White Hill Wind Farm

Annex 1.8: Consultation Responses

**RE: Pre-Application Scoping Request: Proposed Wind Farm Development in
County Carlow and County Kilkenny.**

**Annex 1 –  
Maps and Drawings**

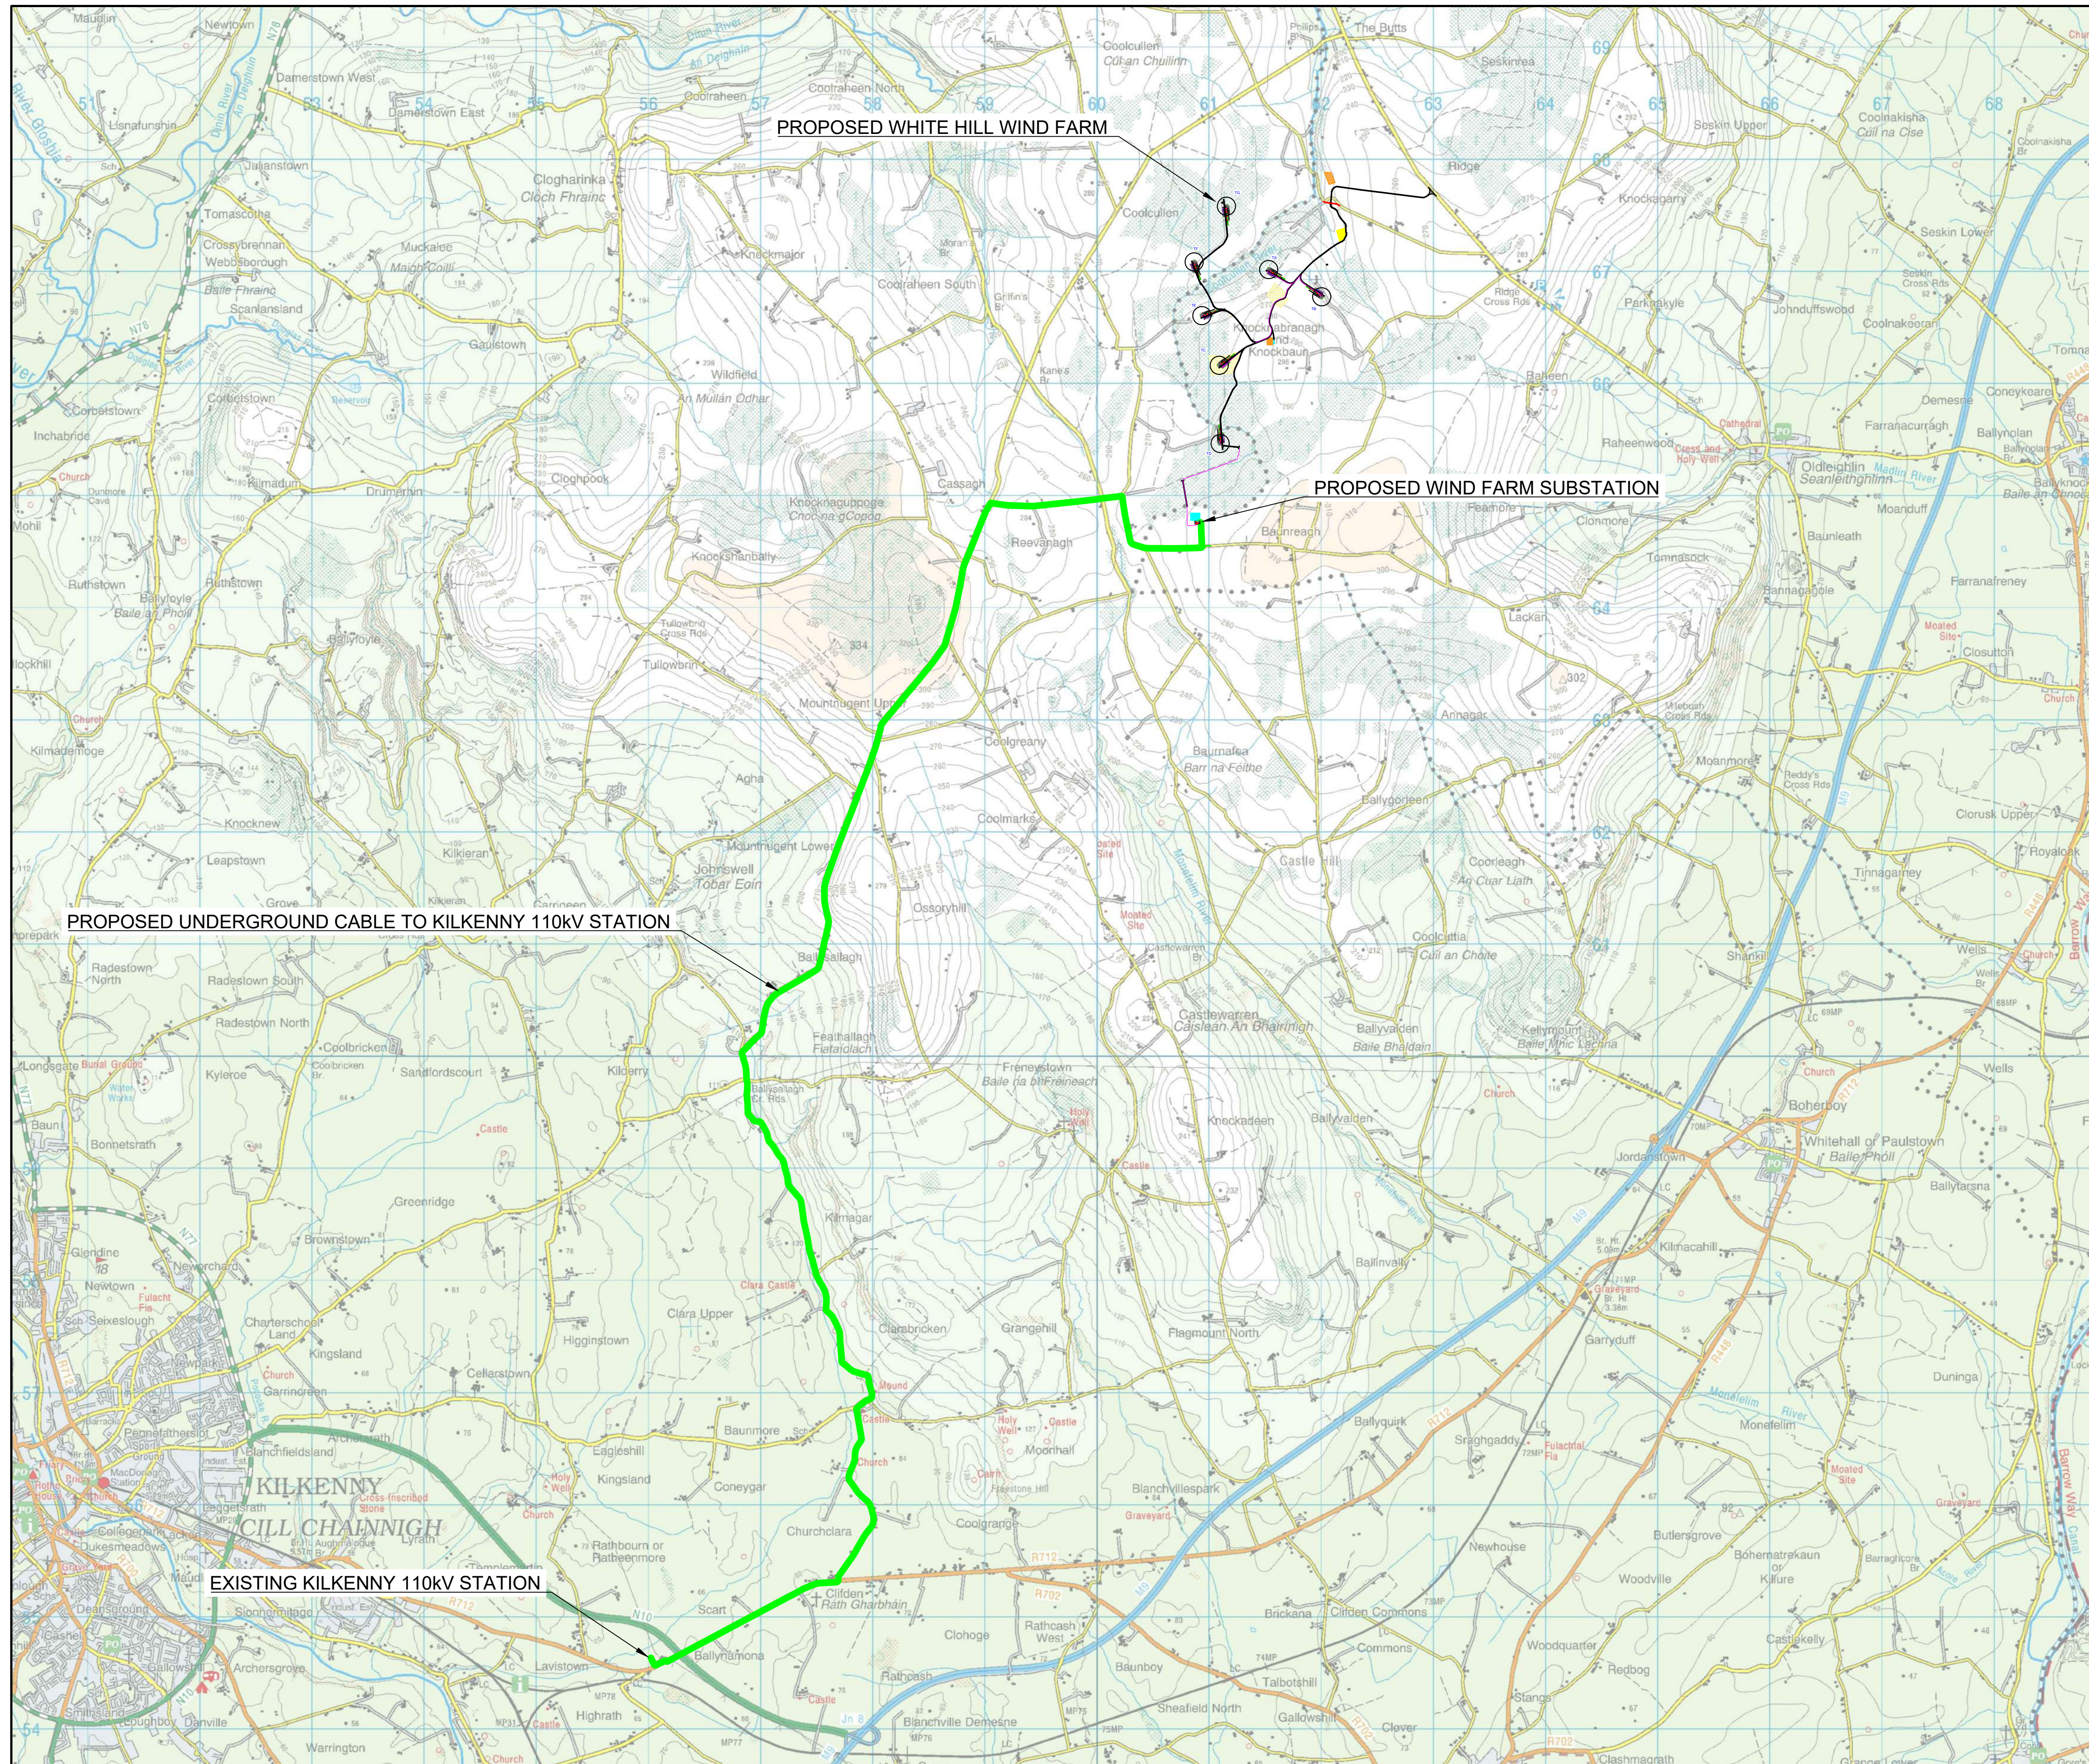
- Figures 1 and 2 included with the submitted scoping report identifies indicative turbine locations close to the public road to the north of the site, the L30371. The L7123 and L3937 are designated scenic routes (no. 6 – Ridge Cross, no.7 road to Butts). The proposed development has the potential to negatively impact on the scenic value of this route.
